CHICK-FIL-A POWERS & PALMER

PORTION OF LOT 1, BLOCK 1, WALDORF SUBDIVISION
LOCATED IN THE SOUTHWEST QUARTER OF THE SOUTHWEST QUARTER OF SECTION 6
TOWNSHIP 14 SOUTH, RANGE 65 WEST OF THE 6th P.M.
CITY OF COLORADO SPRINGS, COUNTY OF EL PASO, STATE OF COLORADO

Site Development Plan

LOT OVERVIEW MAP

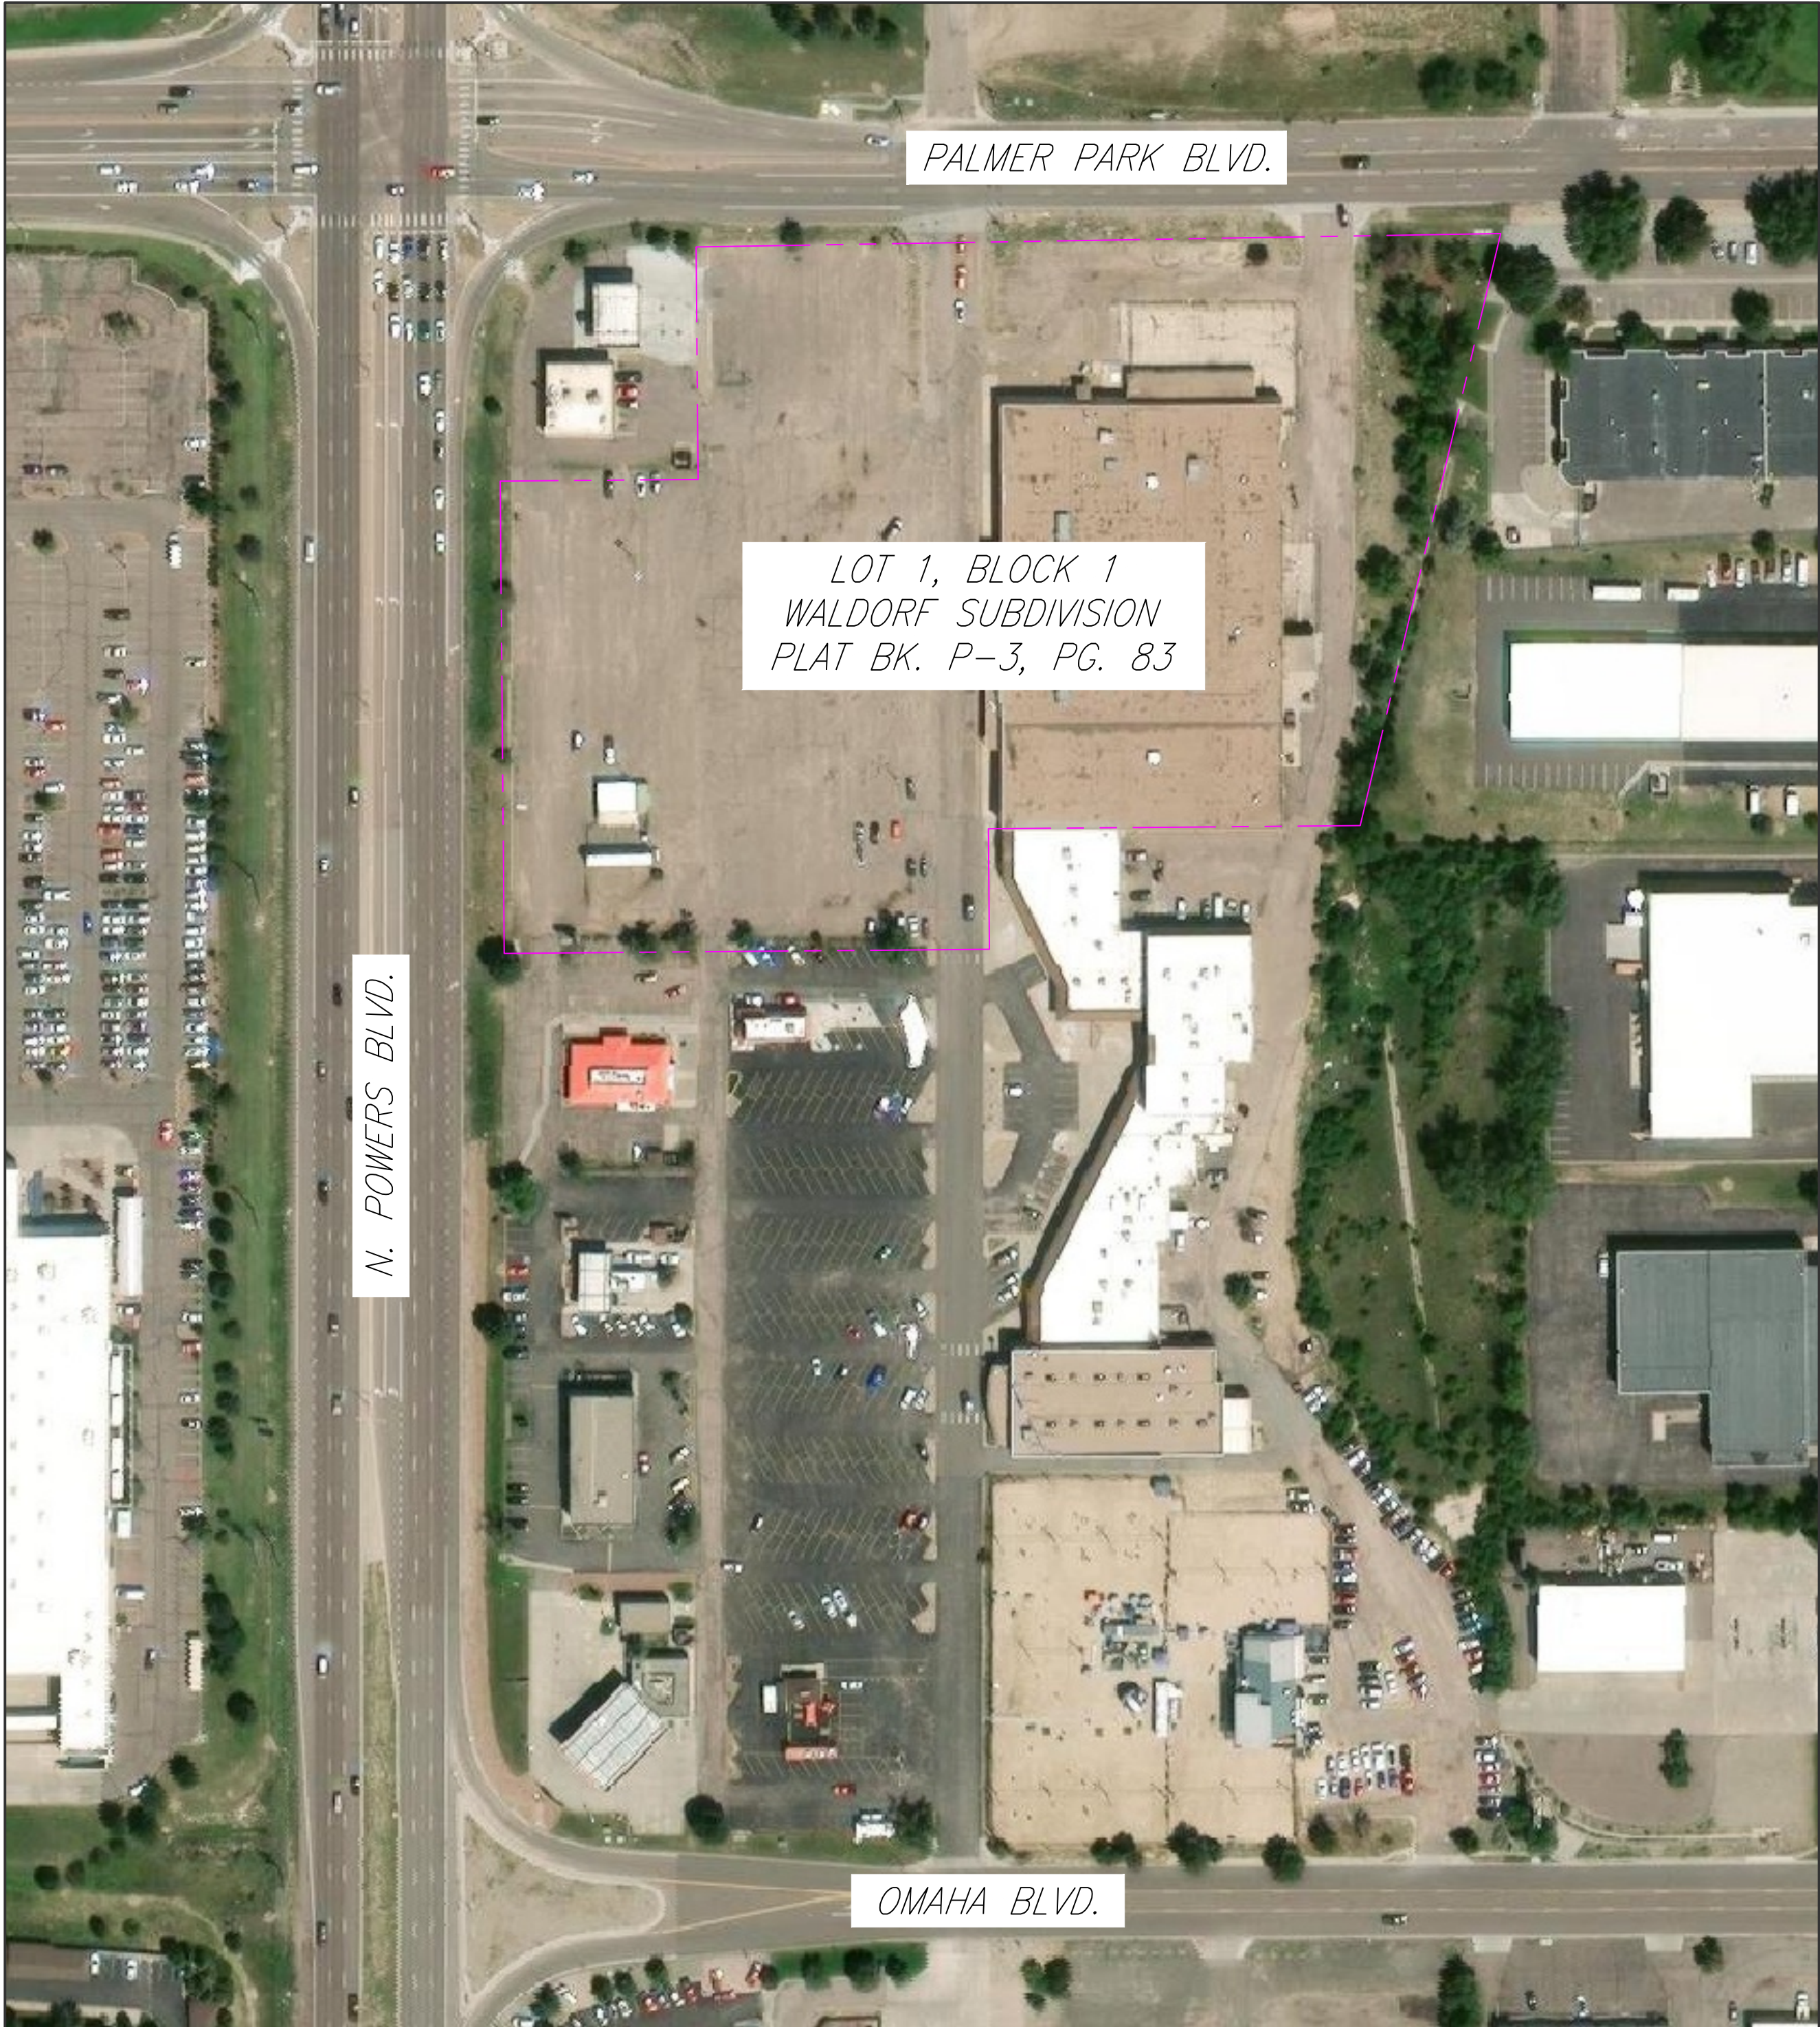
Provide a site plan overview of the entire property boundary of LOT #1

SITE PLAN
OVERVIEW
MAP
PROVIDED

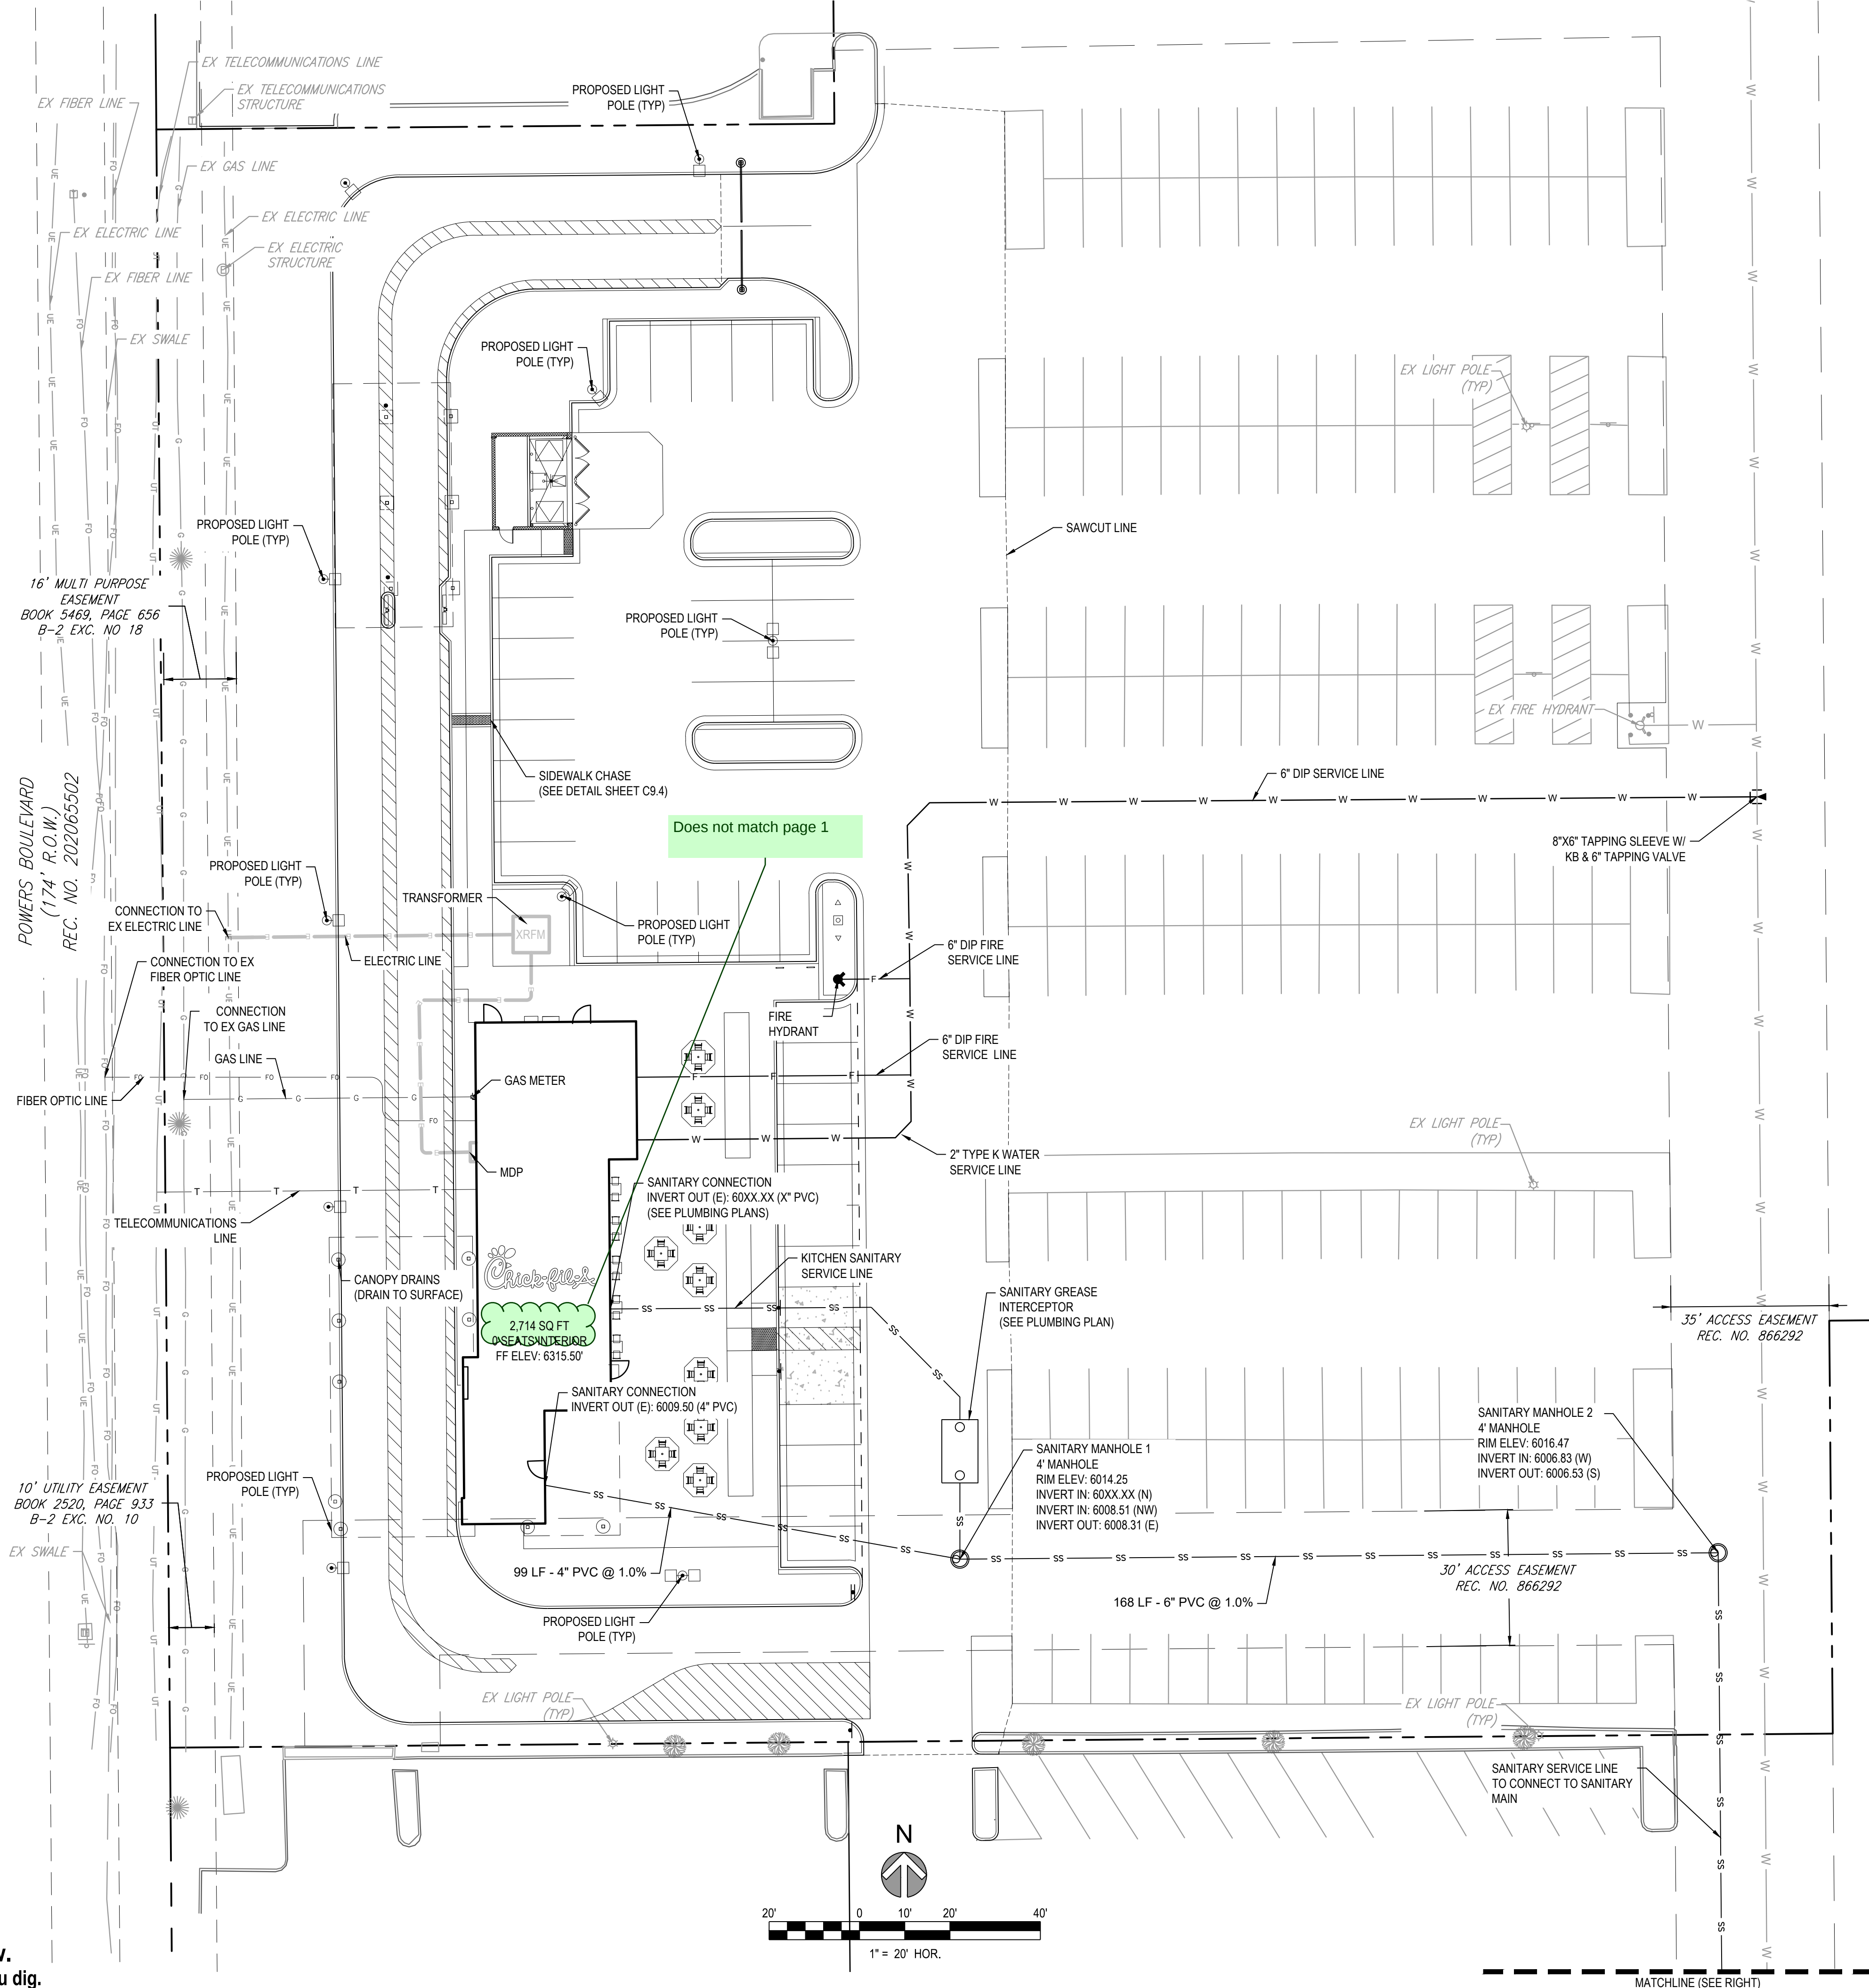
Label adjacent property
LOT 2 BLK 1 WALDORF SUB
Parcel 5406304001

call out existing or
proposed

Is this zero seats
interior? Please
correct to zero (0)

Label adjacent
property

Provide parking analysis
for the complete property
and all uses to include
the fitness center in LOT
#1

Provide a Pedestrian Access
Route along Palmer Park into lot
and site IAW ECM Chpt 6
requirements. Sidewalks are
missing along frontage.

Depict traffic circulation flow in and out of property to
adjacent public streets and access point

Pursuant to the Site Development
Plan checklist at the link below,
please include a table calculating
open space, landscaping, and
impermeable surface percentage.

Please clarify. The
plan only depicts 38
spots and 2 ADA
spots.

ADJACENT
PROPERTY
LABELED AND
PROPOSED AND
EXISTING CURB
CALLED OUT

ADJACENT
PROPERTY
LABELED

THE PARKING ANALYSIS IS
IN PROCESS WITH THE
LANDLORD AND ADJACENT
LOT INCLUDING THE
FITNESS CENTER

OUR CIVIL SITE
SCOPE DOES
NOT
ENCOMPASS
IMPROVEMENTS
ALONG PALMER
PARK BLVD. LOT
2 BLOCK 1 IS
ALONG PLAMER
PARK BLVD

THE TRAFFIC
CIRCULATION
FLOW IS IN
PROCESS WITH
THE LANDLORD
AND ADJACENT
LOT INCLUDING
THE FITNESS
CENTER

SITE DEVELOPMENT PLAN
PROJECT DATA TABLE
UPATED PER THE SITE
DEVELOPMENT PLAN
CHECKLIST

PARKING
COUNT
CLARIFIED
